From: Iain Osenton
Sent: 26 April 2024 11:50
To: Planning; dcregistration
Cc: Laura Bell
Subject: 24/00539/F - CDC Arboriculture

From desk based assessment.
Comment – Objective.

**TREE REMOVAL & ARBORICULTURAL IMPACT ASSESSMENT PLAN**

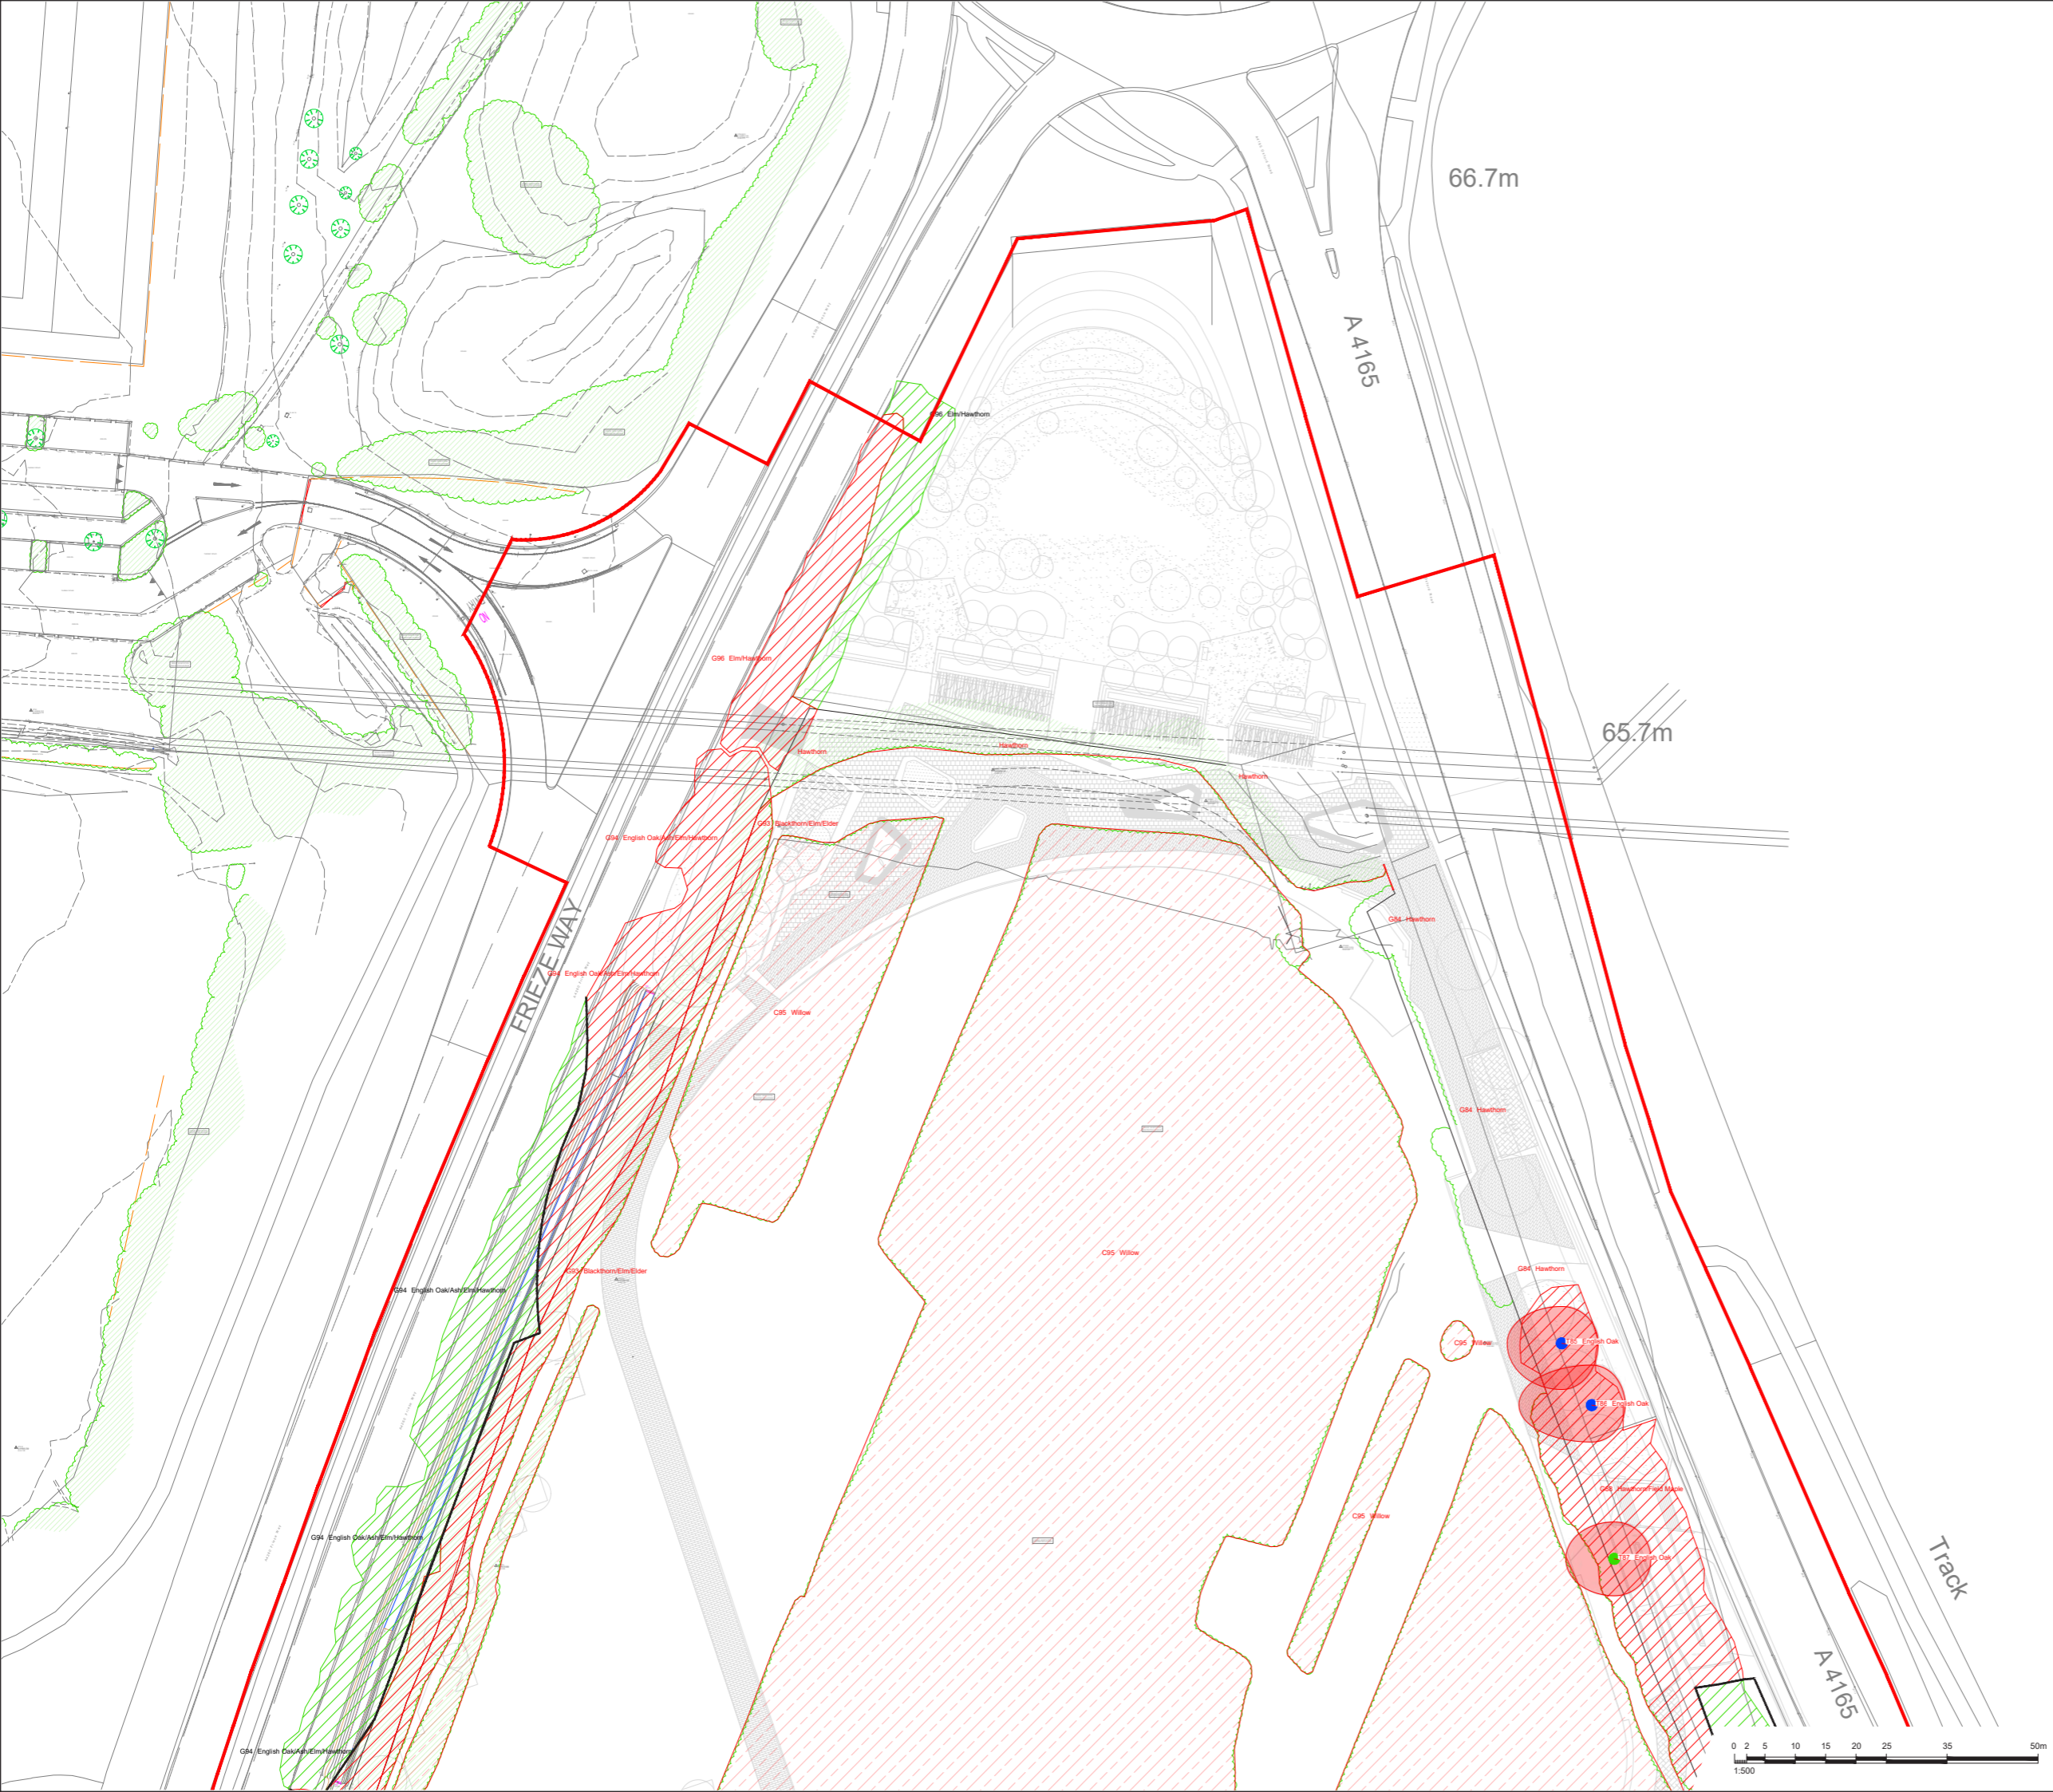
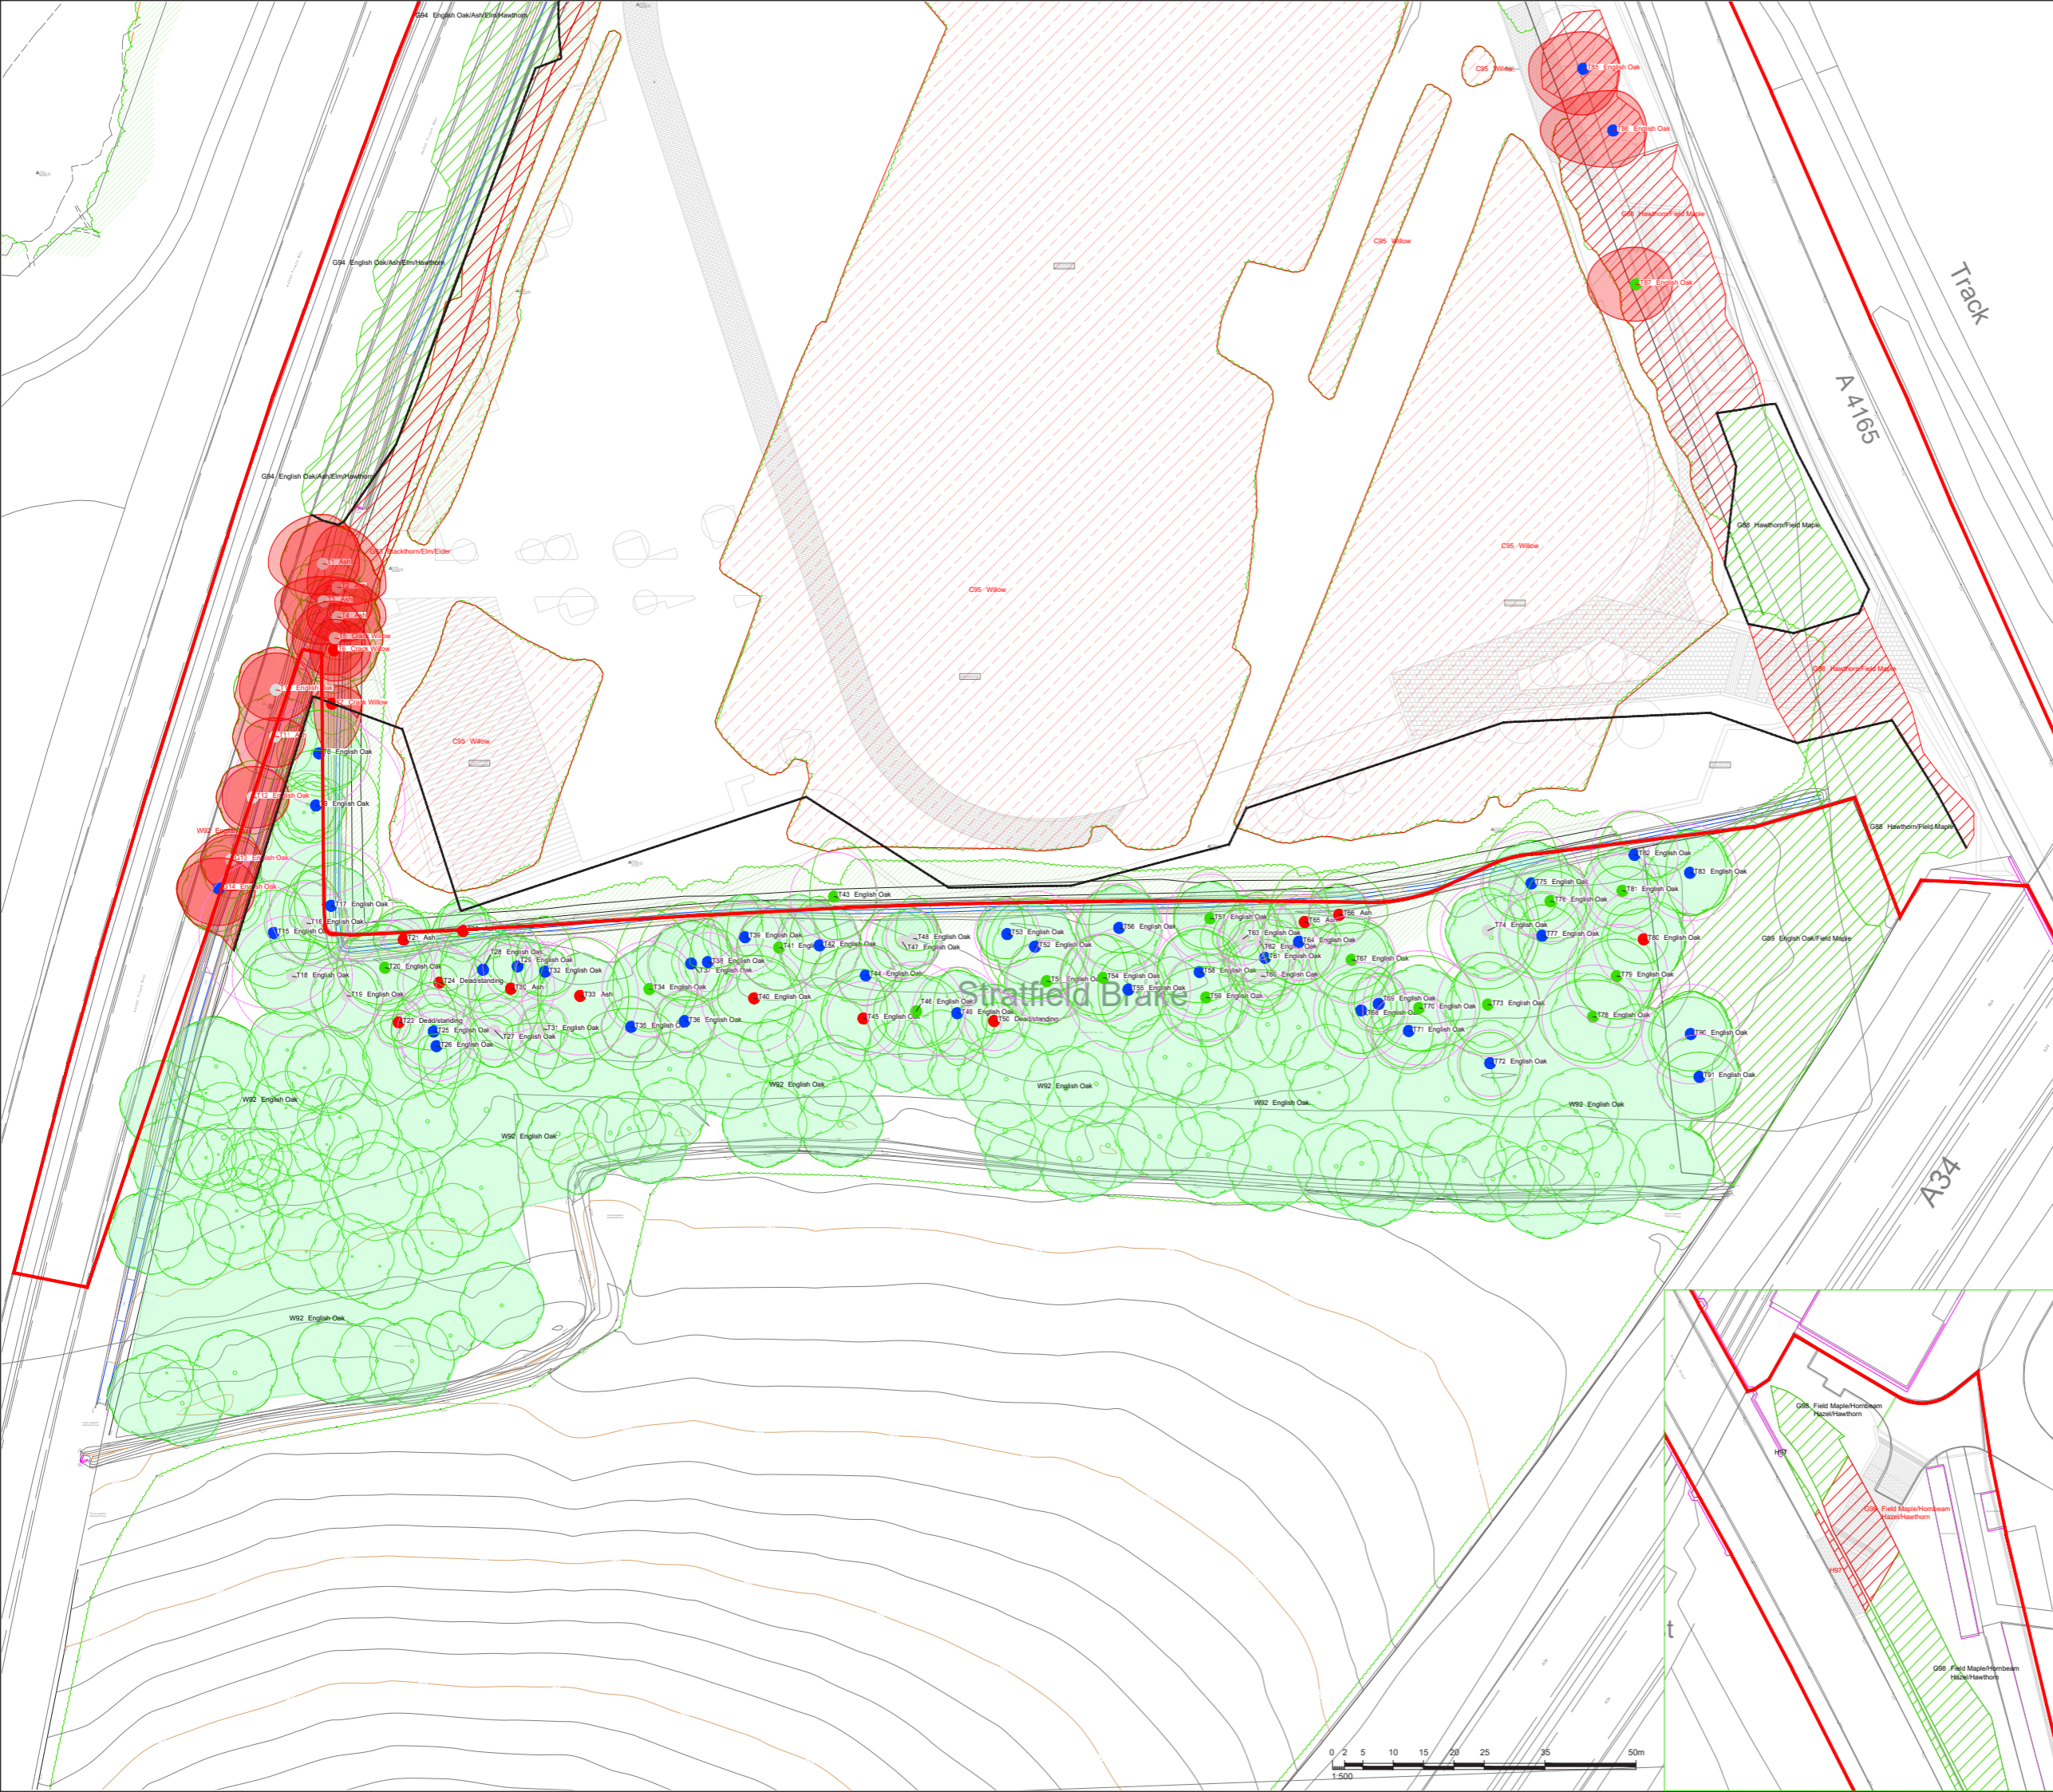
In principle, the proposal seeks to retain the majority of individual features within and adjacent to the site. However, a majority of the surveyed trees are situated within the woodland to the south of the proposal, far beyond any area of proposed development. Considering trees immediately adjacent, or within the area of proposed development, this proposal offers a higher arboricultural impact.

The proposal requires the removal of significant sections of hedgerow upon both the east and west boundary. G94 on the west boundary has not been detailed within the arboricultural report, the impact of its removal therefore cannot be considered. On the east boundary, x2 trees awarded BS5837 category B, subject to a preservation order have been marked for removal, in addition to x1 category A feature. This represents removal of the only individually identified features on the east boundary. These features offer amenity to the adjacent highway and footpath, with public interest in their protection.

Based on my initial assessment I'd suggest the proposal in practice offers greater arboricultural impact than the proposal suggests on the surface, with removal of high value arboricultural features, I propose conflict is present in line with BS5837:2012 as the proposal hasn't considered the high value features within the site. So landscaping proposals detail tree planting on the east boundary to replace trees lost, I would argue retention of features to be of higher value than removal and replacement, in the interests of preserving existing amenity and biodiversity.
